PLANNING CONSULTATION RESPONSE

Application No	2025/1092
Proposal	Demolition of existing non-motorised user (NMU) bridge, and construction of replacement NMU bridge
Address	Non-motorised user (NMU) bridge over A633 Grange Lane (A633), Stairfoot, Barnsley
Date of Consultation Reply	02/07/2026
Consultee	Claire Wilson, Planning Ecologist

Drawing Title: **Landscape General Arrangement Planning Application**

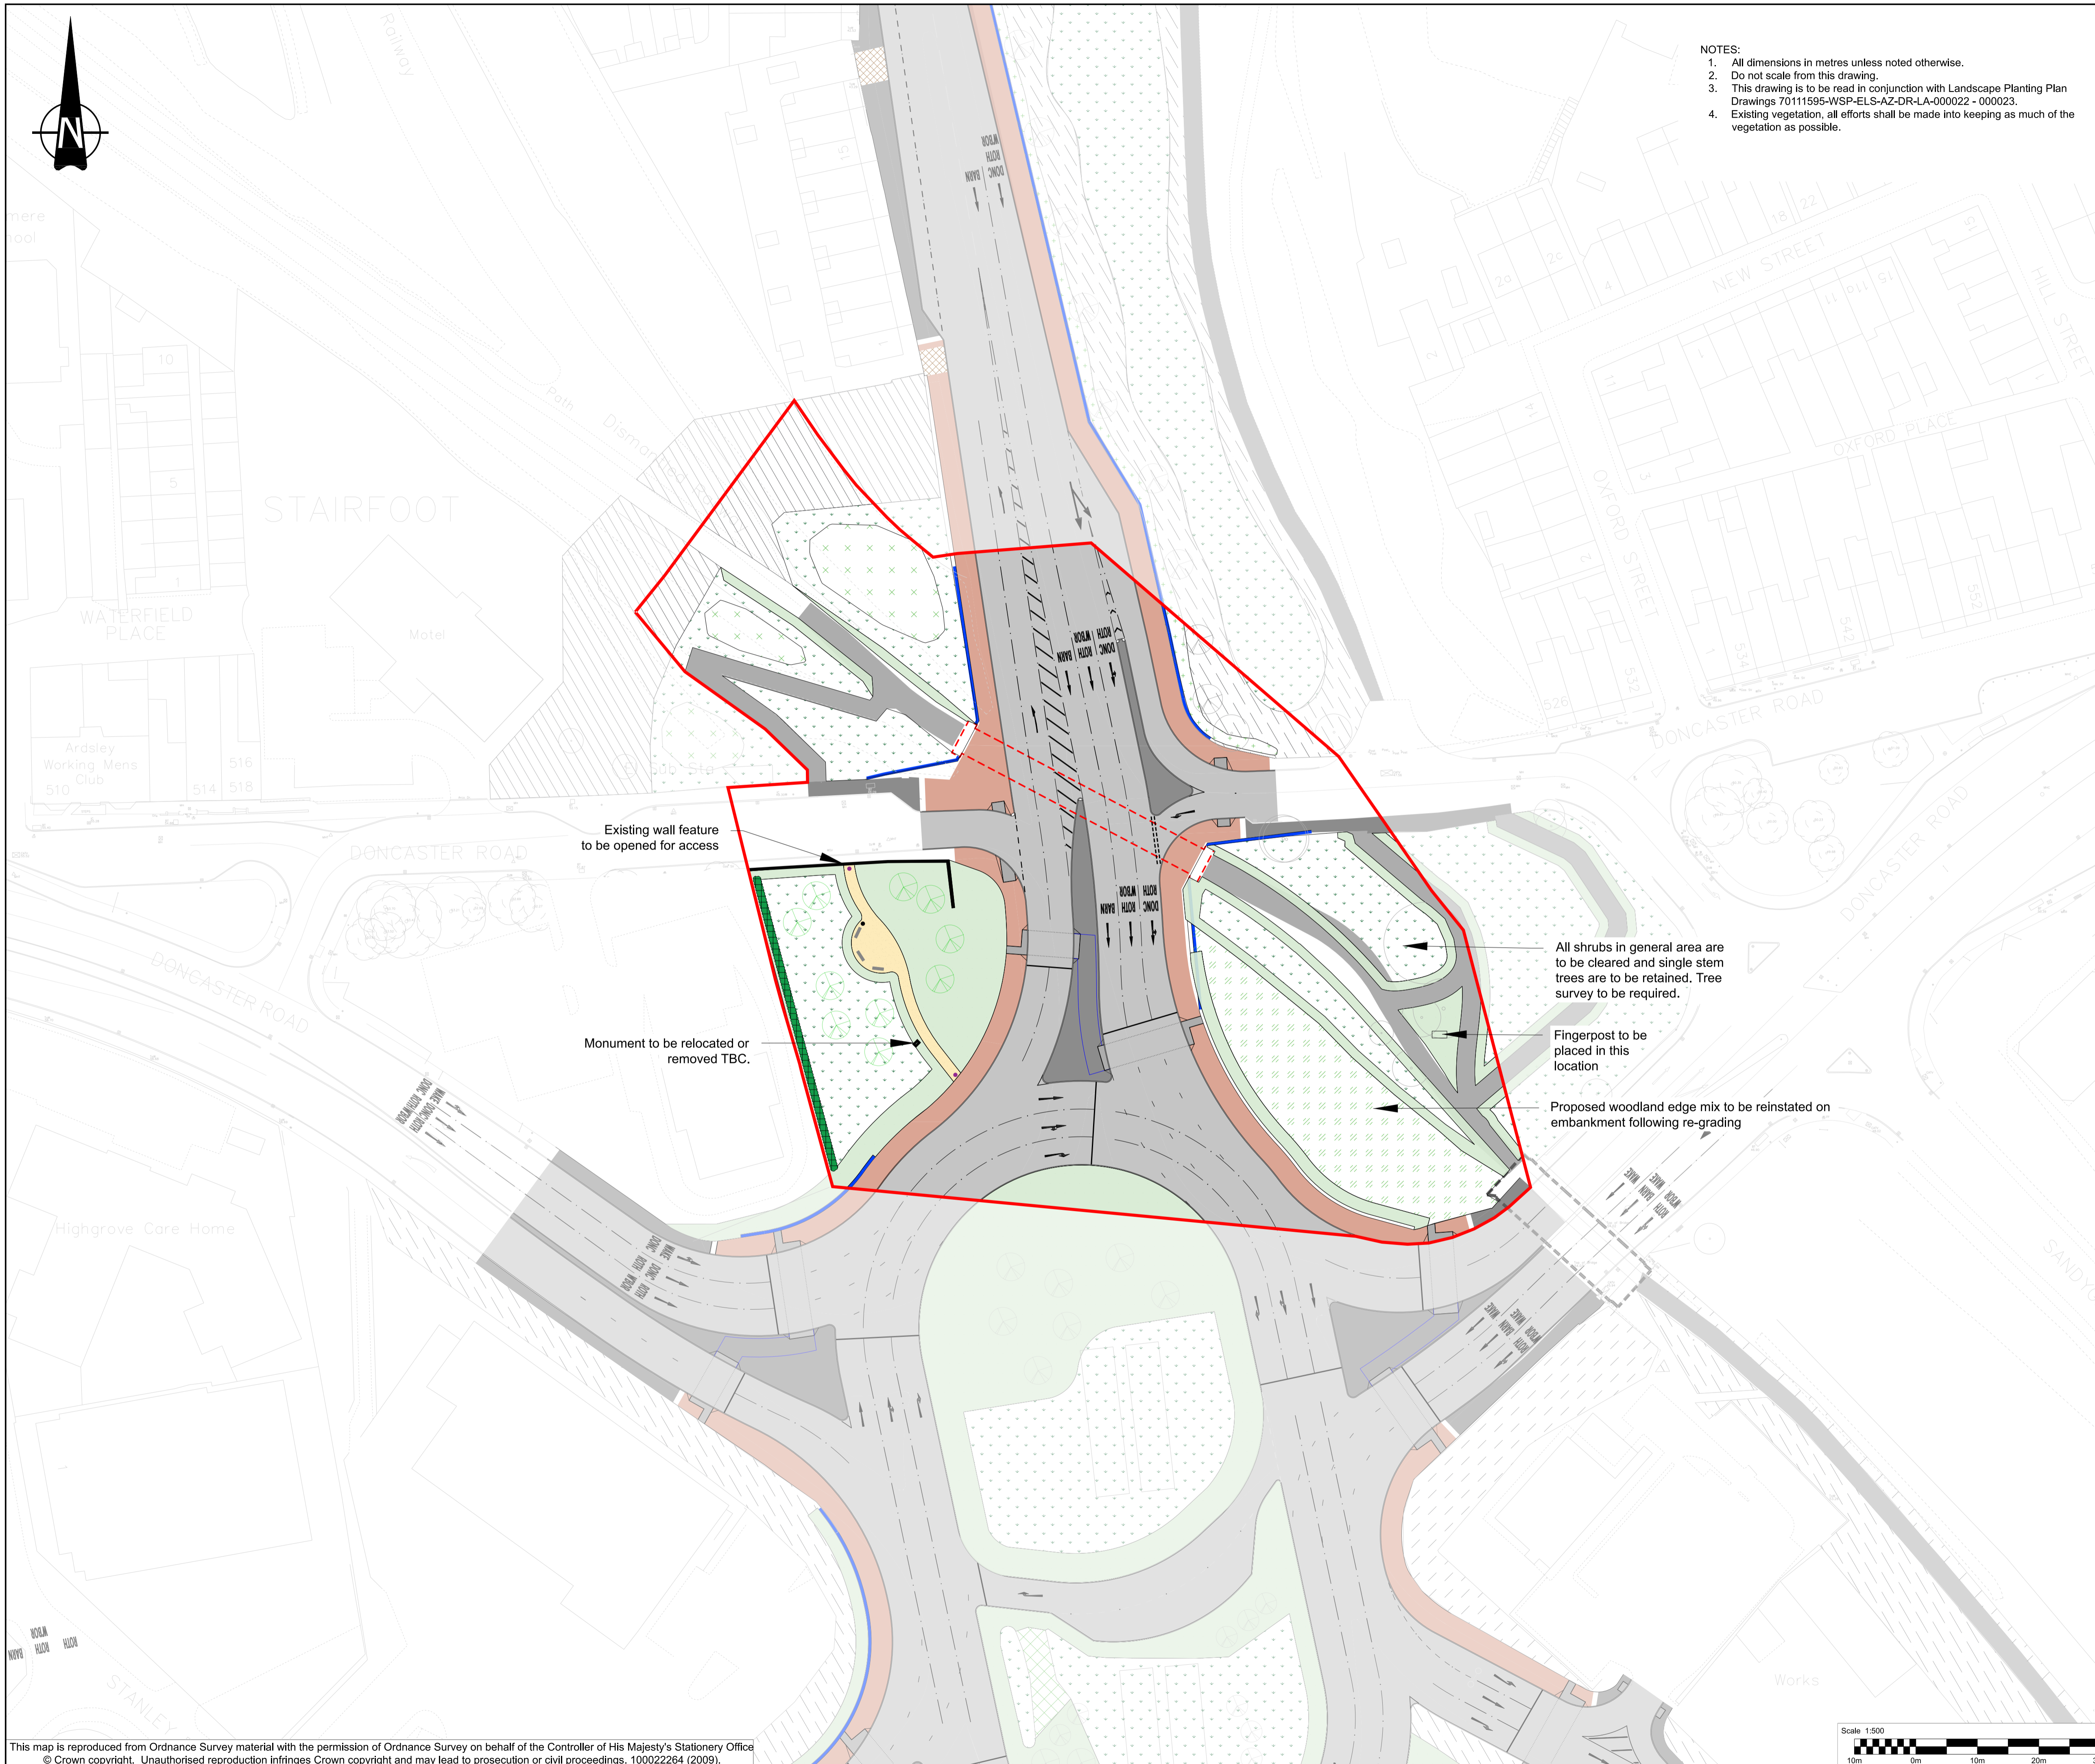
Neither the updated PEA nor the metric identifies the habitats that will be affected by the development. Detailed proposals demonstrating how a minimum 10% biodiversity net gain will be achieved should therefore be submitted as part of the discharge of the Biodiversity Gain condition.

The BNG report identifies a target of 20% net gain, which is welcomed. However, given the limited extent of the site, this uplift is unlikely to be achieved within the application boundary and will therefore require the purchase of off-site biodiversity units. There may also be an opportunity to secure the additional uplift in biodiversity units through habitat enhancement works within Stairfoot Local Wildlife Site (LWS).
